Response from Housing Growth and Regeneration
2022/93938 Piazza Shopping Centre, New Street and Albion Street, Huddersfield, HD1 2TR
Change of use from A1 (business retail and storage) to C3 (residential) 34 studio flats at first and second floors and external alterations
Date Responded: 18th January 2023
Responding Officer: Liz Jefferson
Responding Ref:

Proposed Second Floor Plan

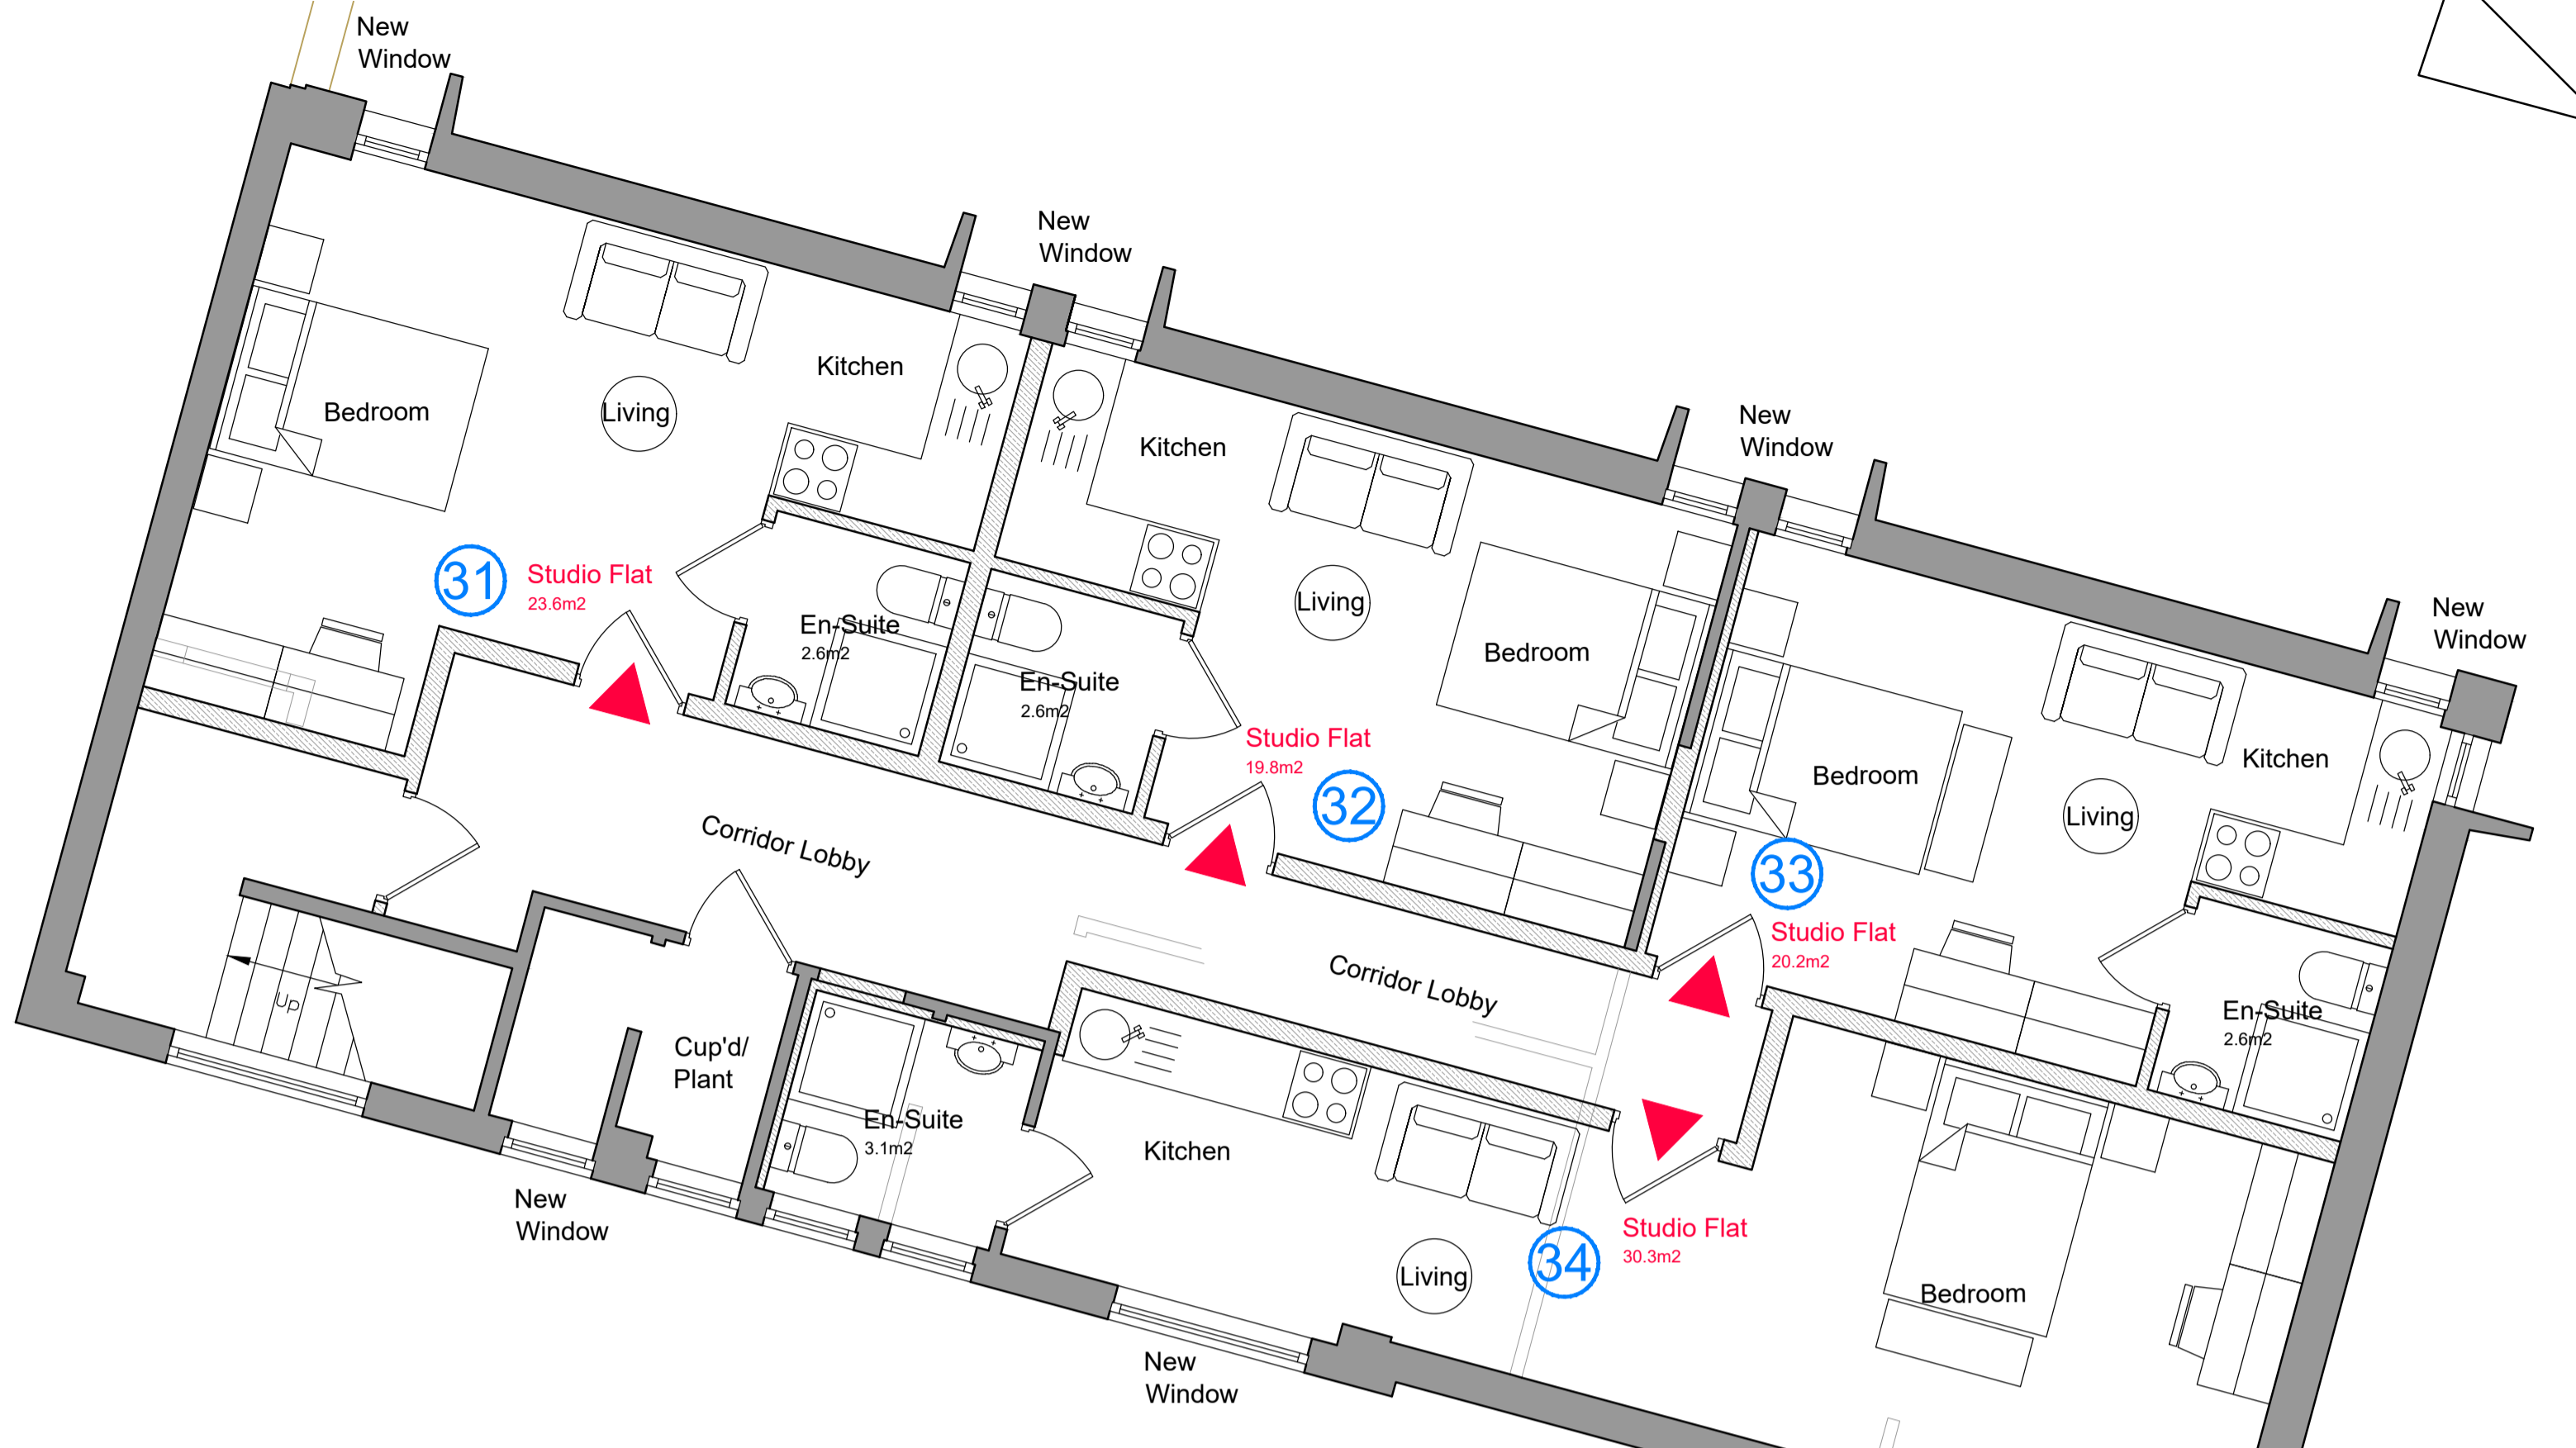
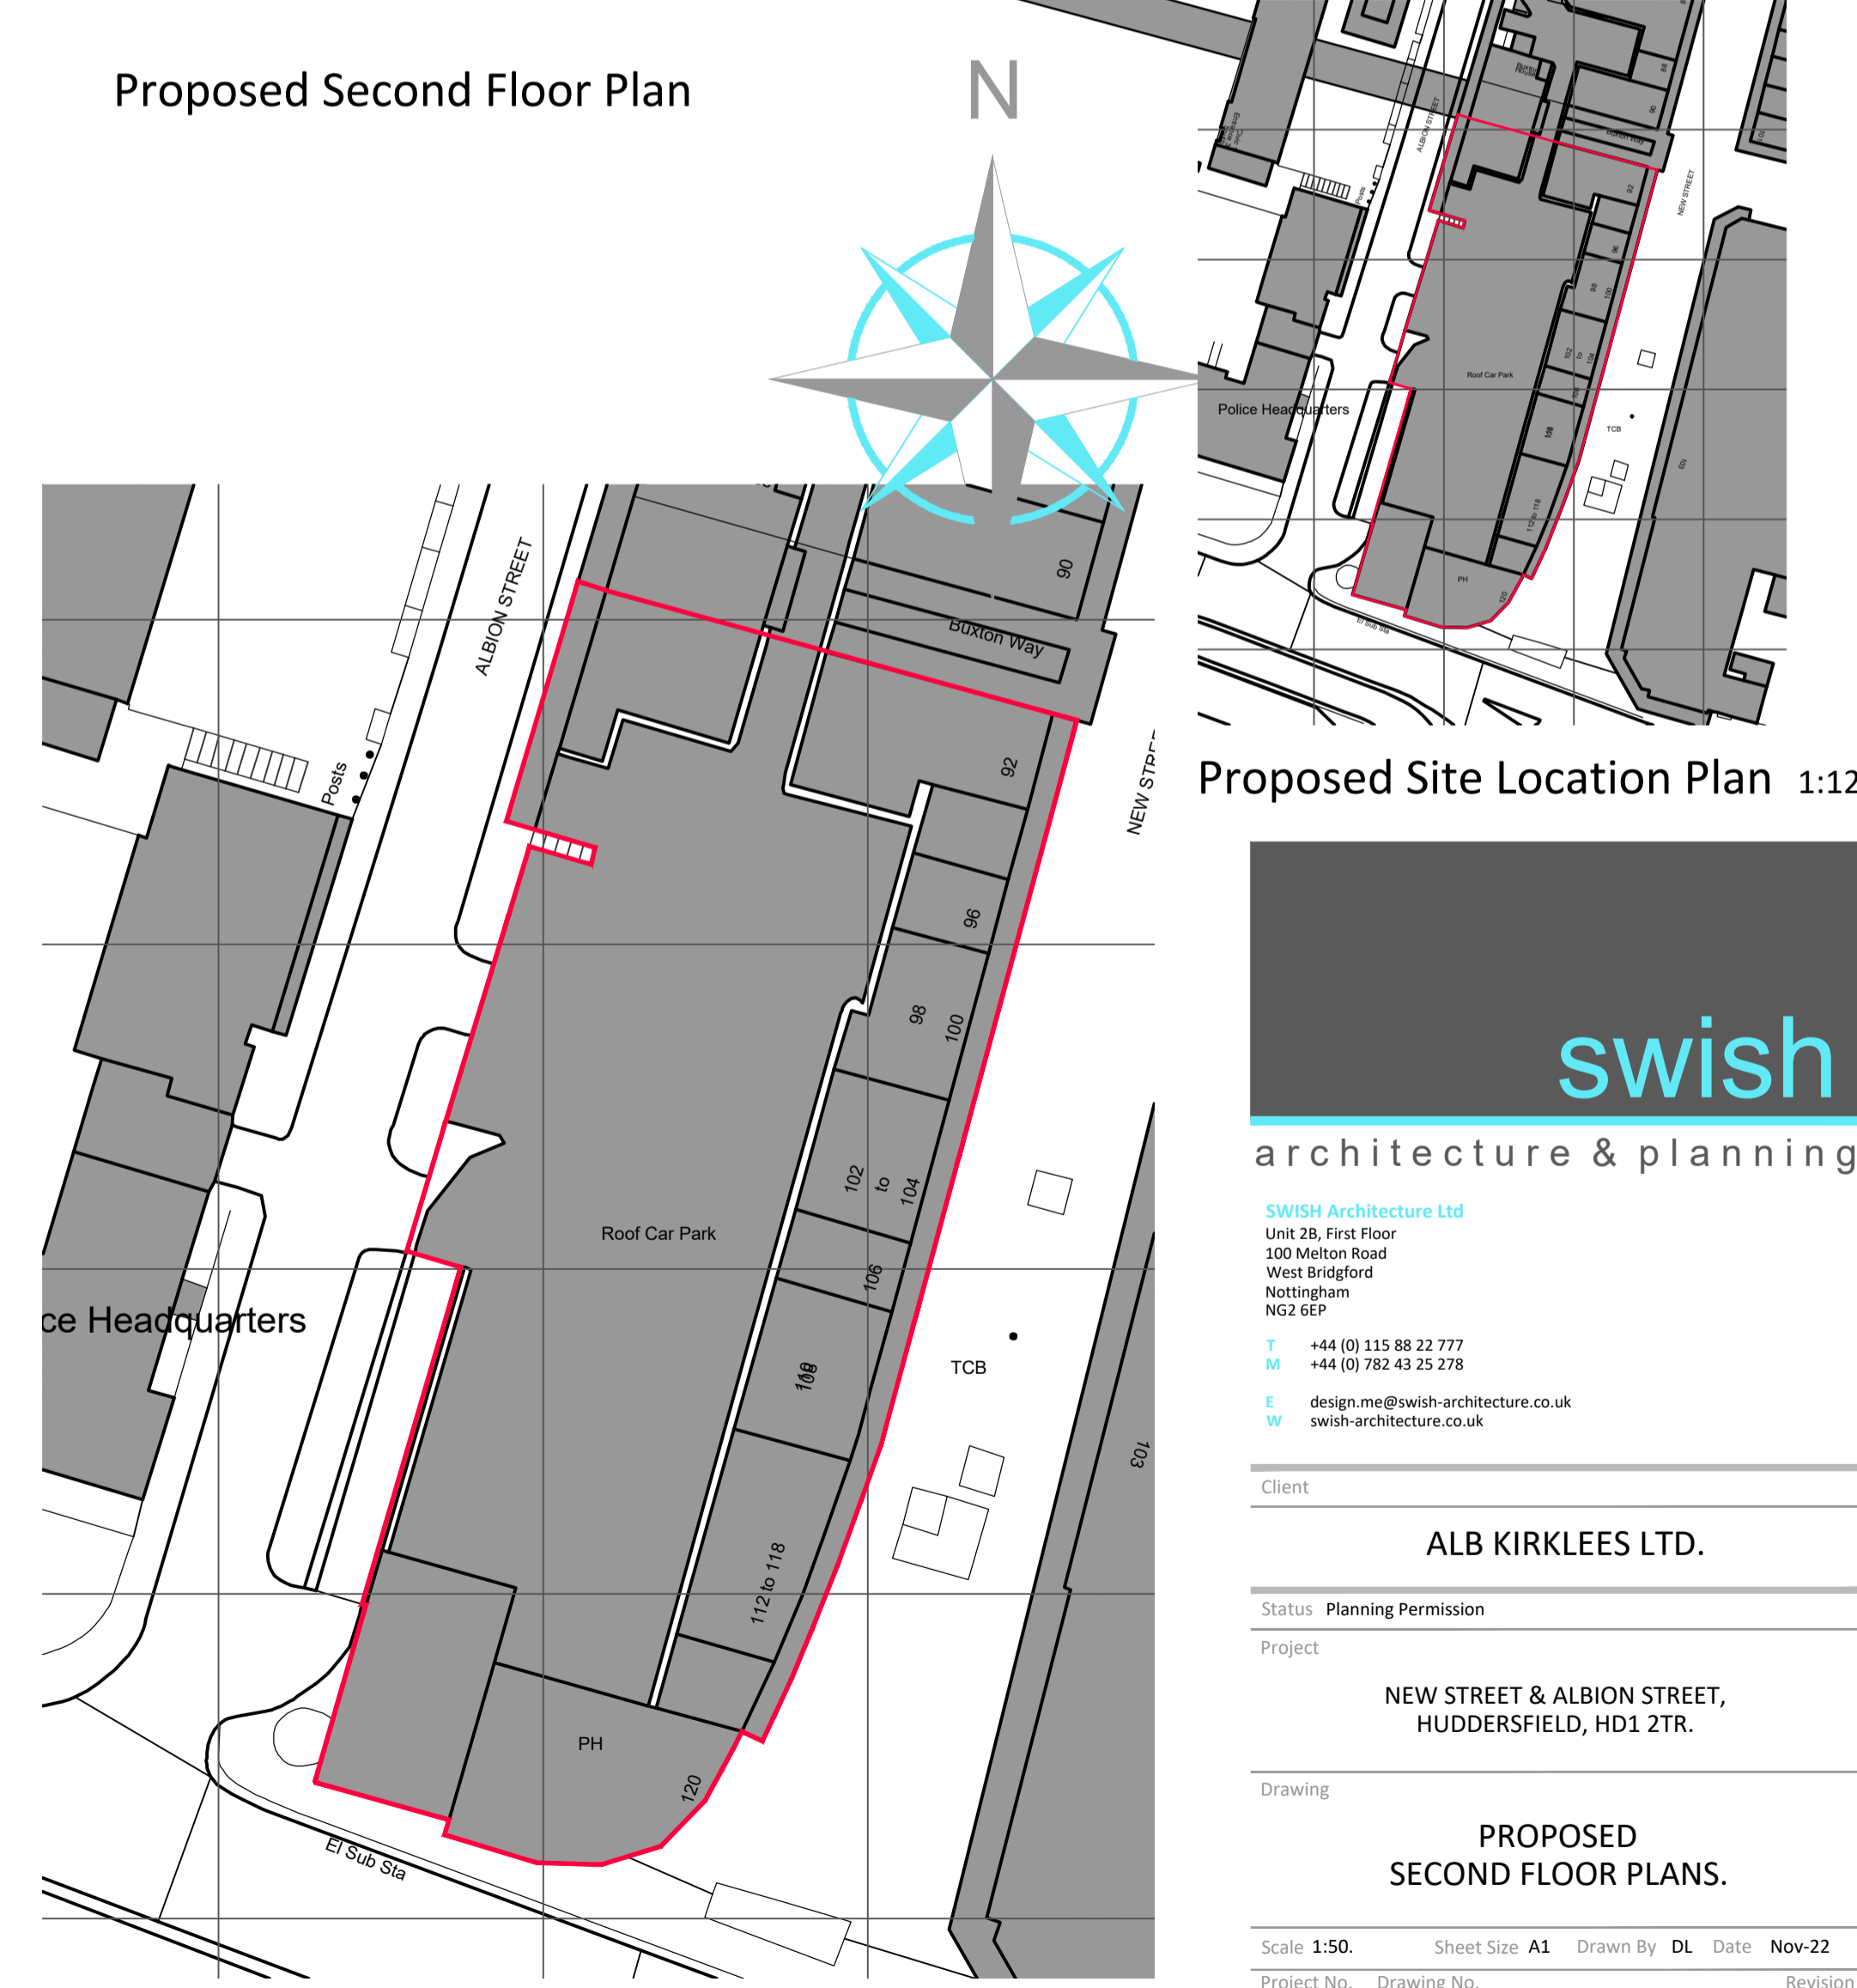
The proposed floor areas set out in the accommodation schedule for this application are significantly below the minimum requirements of the nationally described space standard. A new dwelling for one person with one bedroom would require a minimum floor space of 39 square metres or 37 square metres if the dwelling has a shower room instead of a bathroom. The proposals range from 16 sq metres to 30.3 square metres.
